CITY OF ALBUQUERQUE

December 16, 2013

Re: Morrison Supply
Request for Permanent C.O. – Not acceptable
Engineer's Stamp dated: 08-08-13 (K-18/D021)
Certification dated: 12-12-13

GRADING & DRAINAGE PLAN

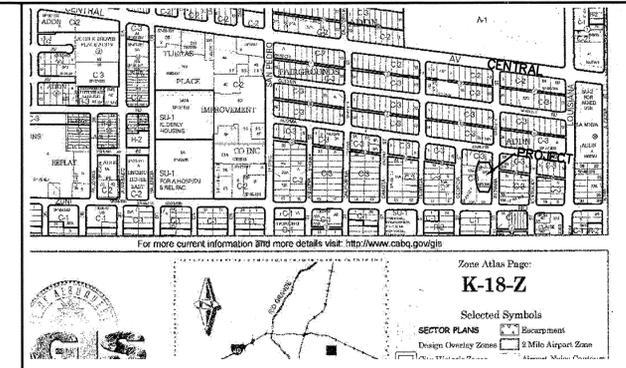
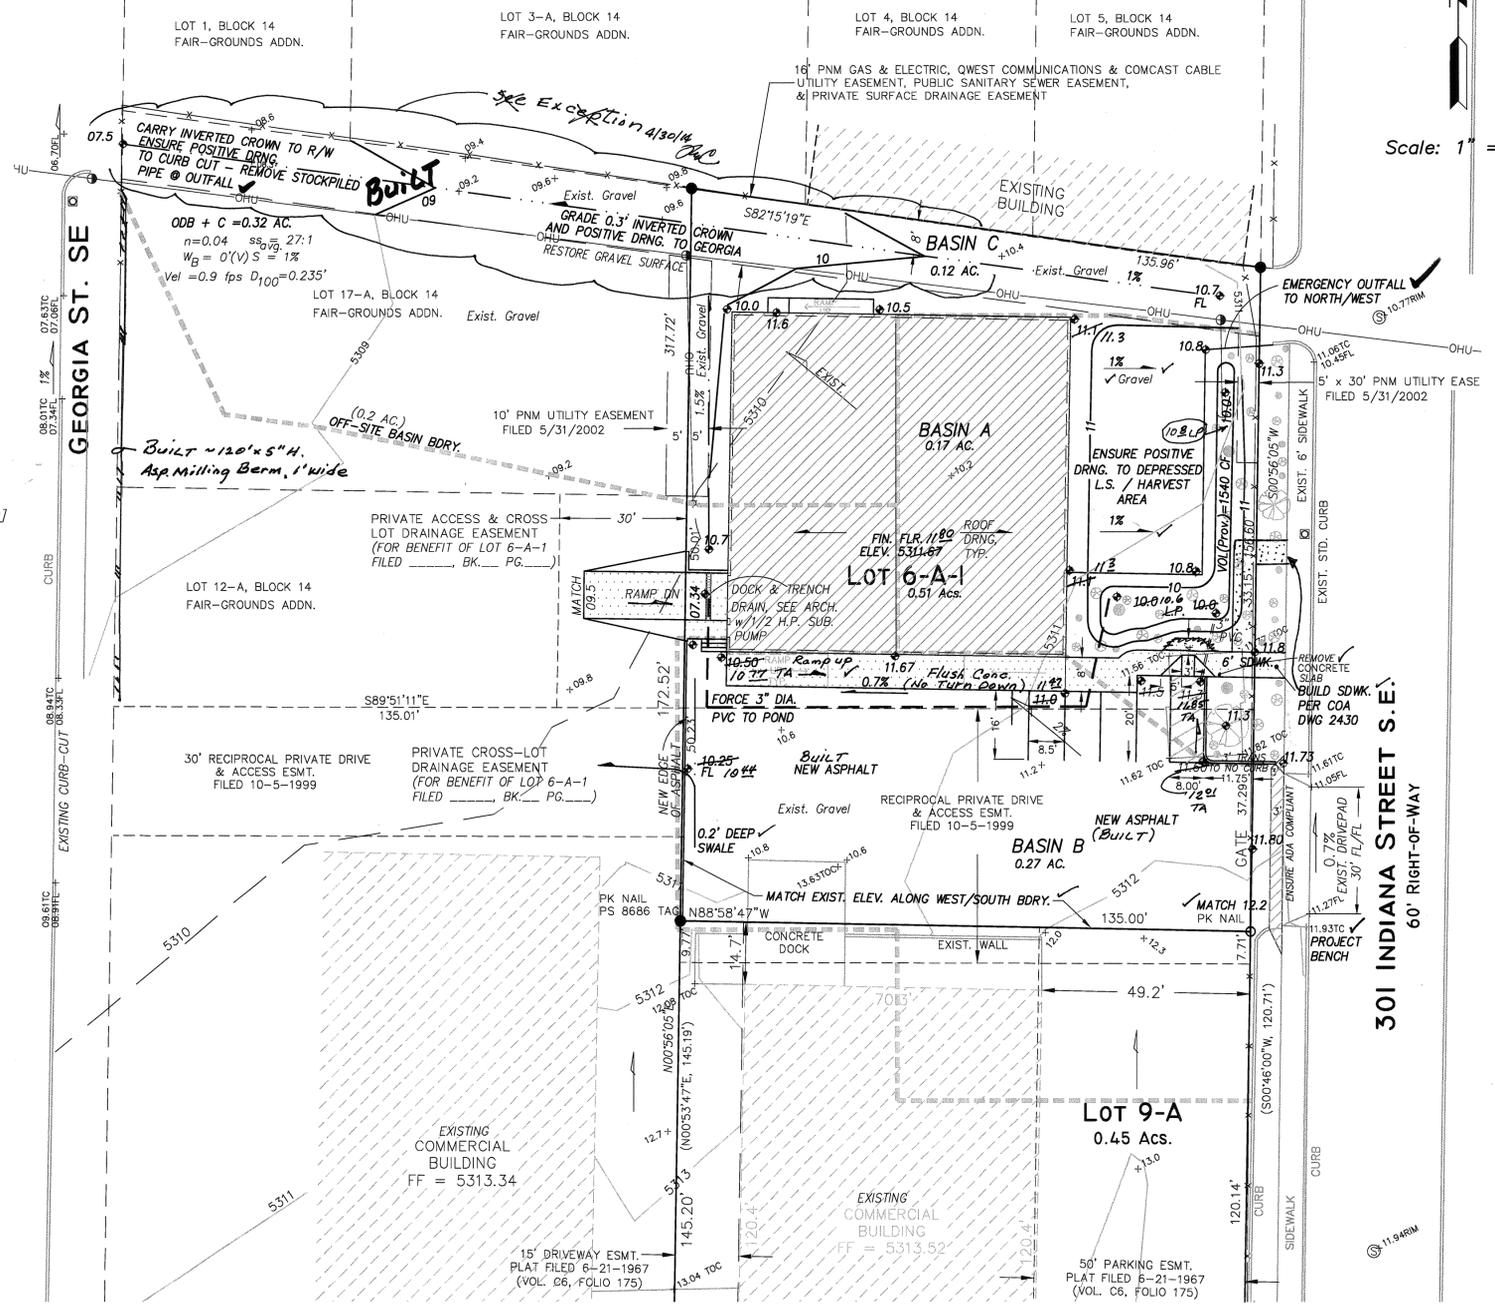
Based on the Certification received 12/12/2013, the site is not acceptable for release of Certificate of Occupancy by Hydrology. The exception for the alley not being graded is appreciated and duly noted. However, because the alley was not graded to ensure positive drainage, flows from the roof and the alley itself are draining toward a building and property to the north, adversely impacting this area.

There are also concerns with the flows to the west of the new building leaving the site over the public sidewalk on Georgia St., leaving debris on the sidewalk adversely affecting the public. These flows should be exiting either the alleyway driveway on Georgia St. or the entry/exit driveway to the south of the alleyway on Georgia St.
